CITY OF ALBUQUERQUE

November 7, 2022

Re: G.A.A.R. Building Renovation
1635 University Blvd. NE
Traffic Circulation Layout
Architect's Stamp 05-20-22 (H15-D008)

A1 TRAFFIC PLAN  
1" = 40'-0"

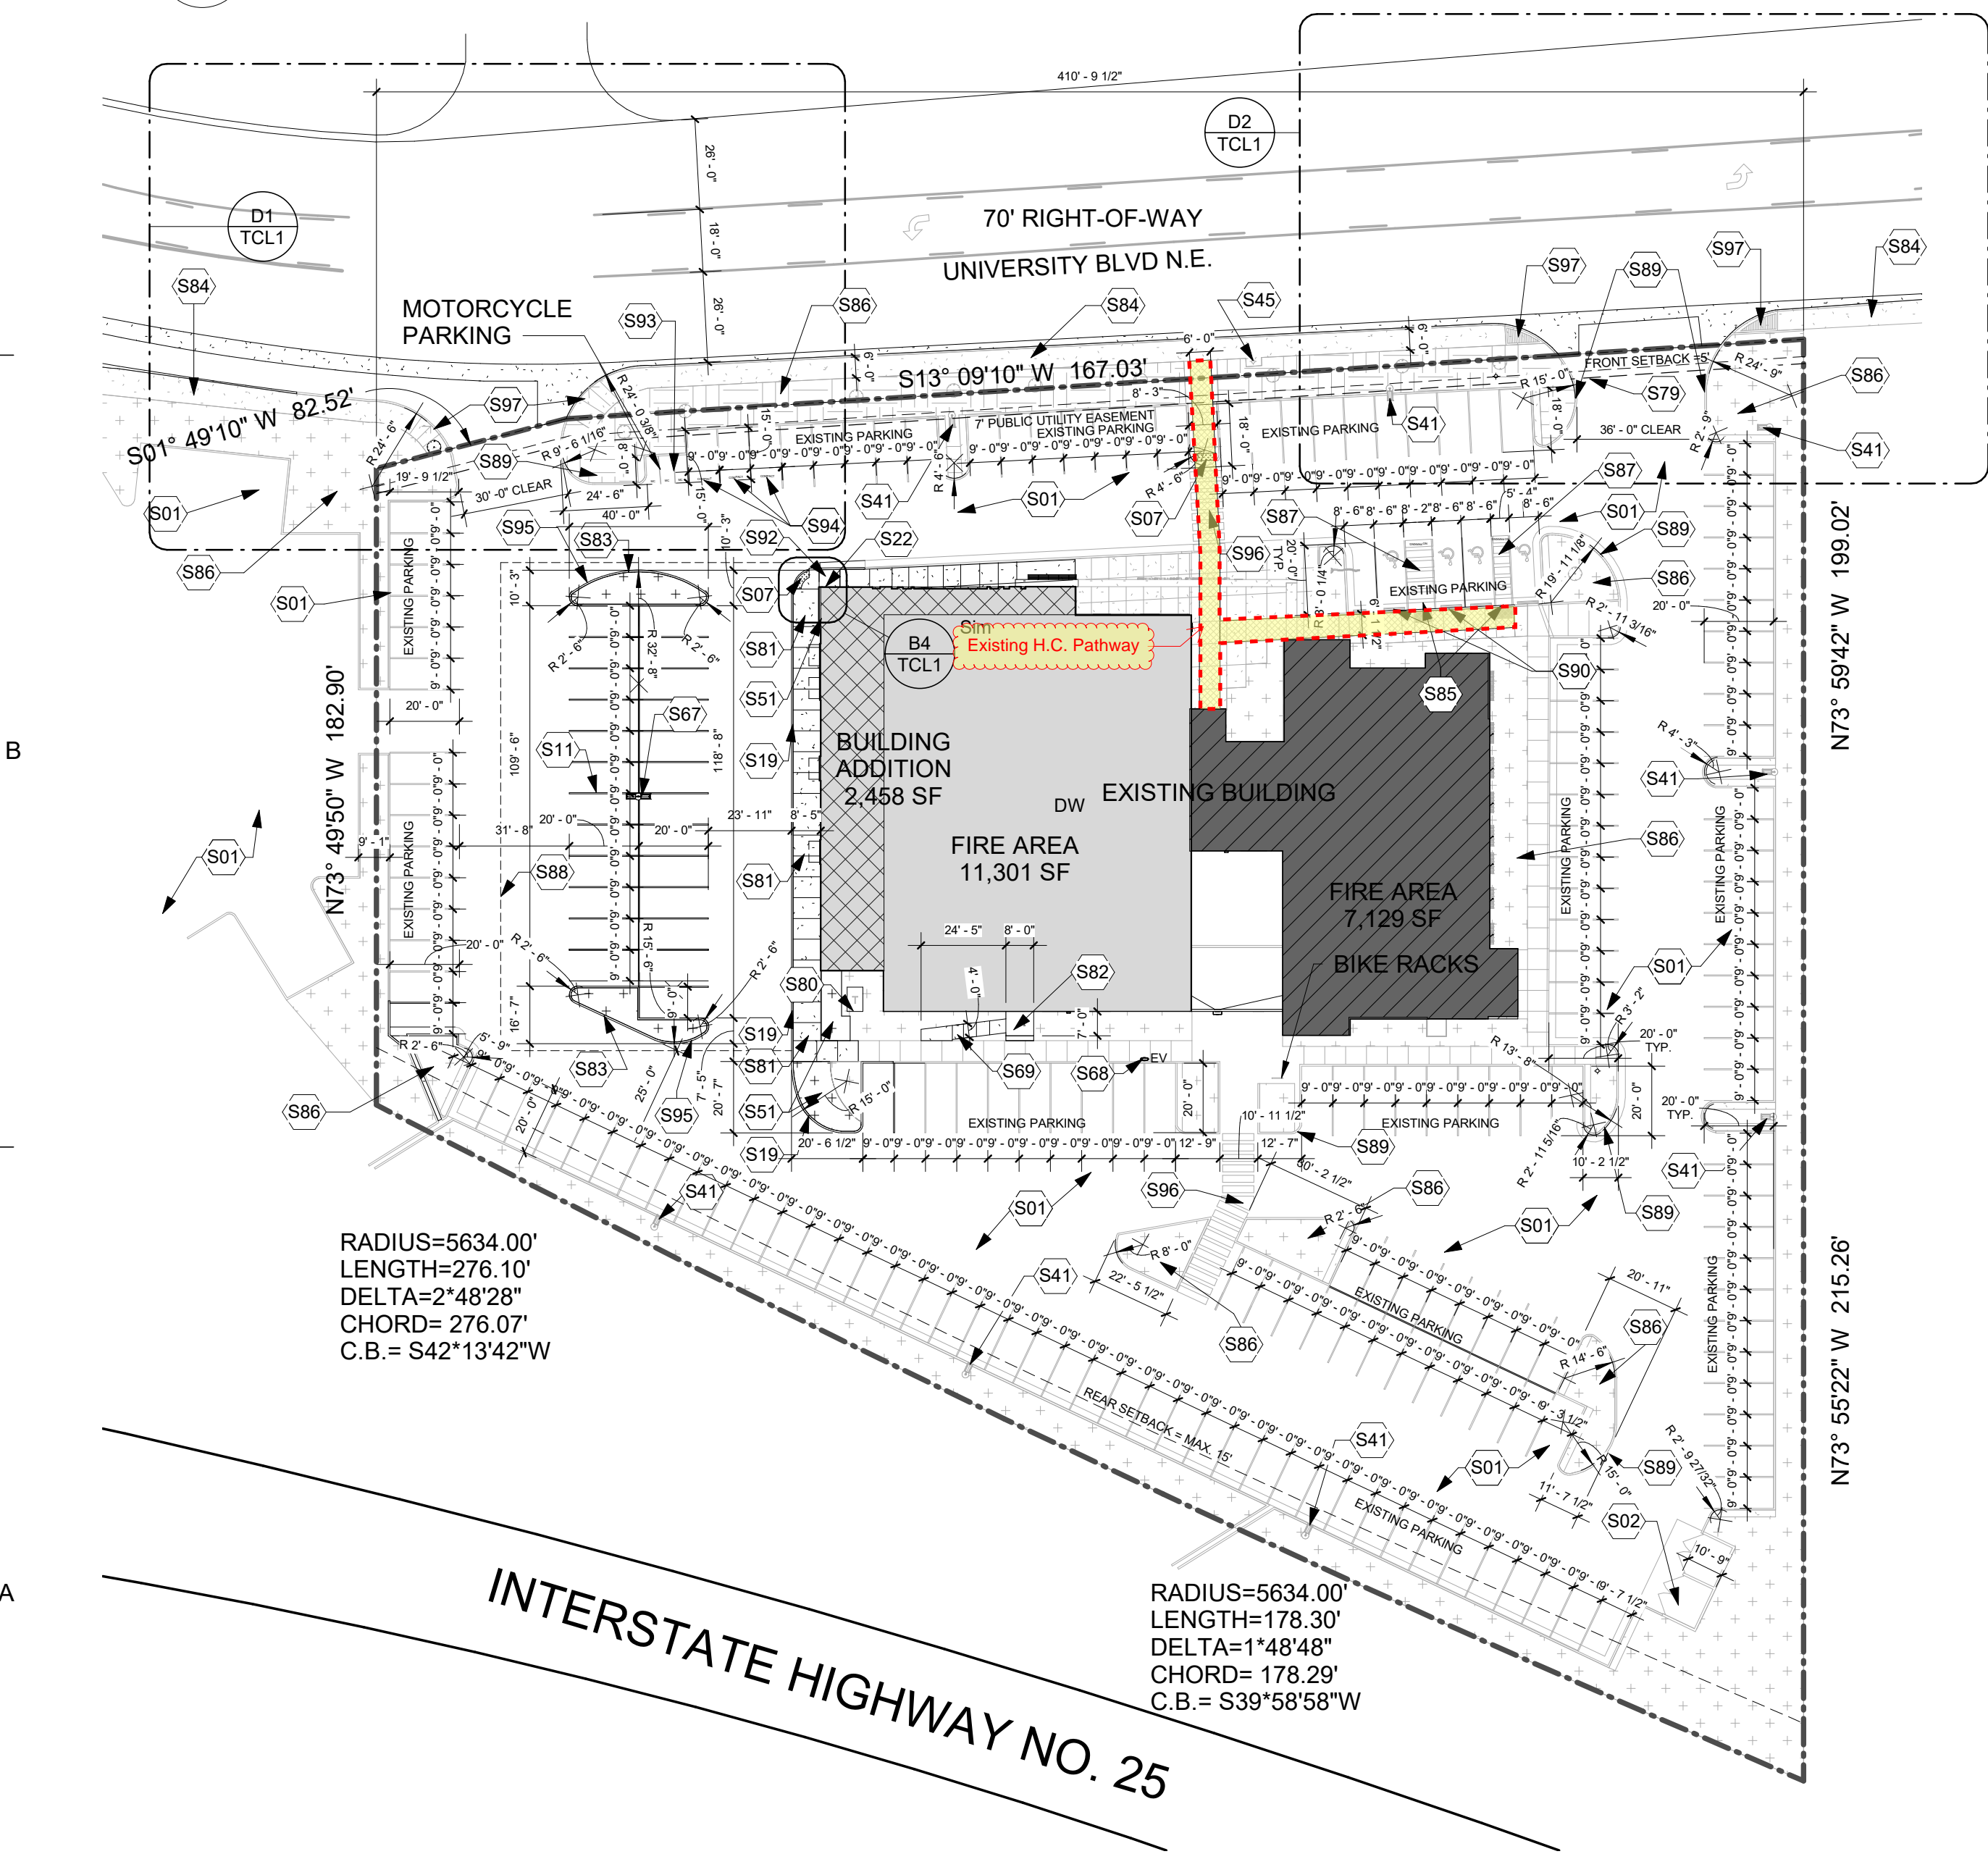
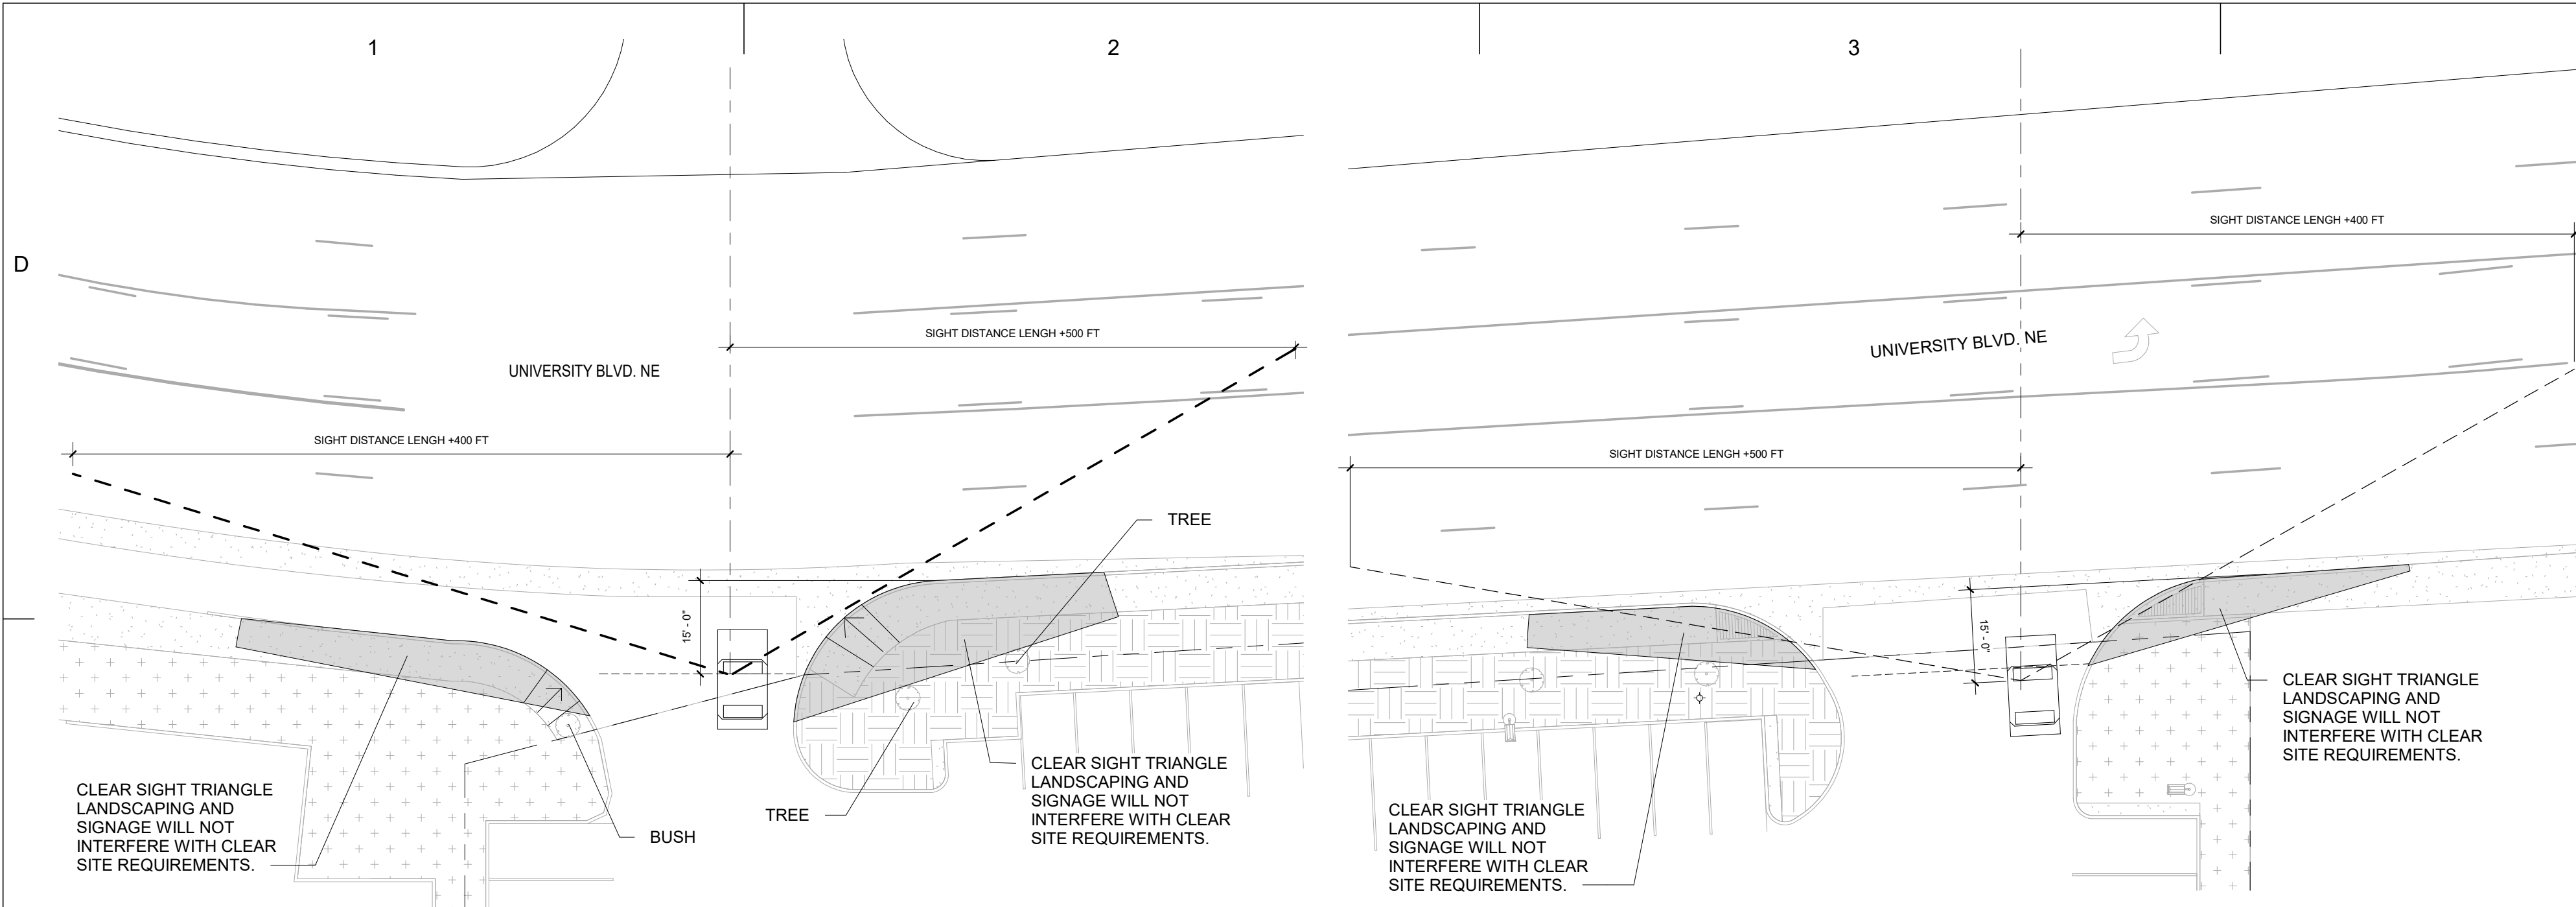
10. Show all drive aisle widths and radii. Some dimensions are not shown.
11. The pavement marking "MC" should be shown in the opposite direction for Motorcycles entering the parking space.
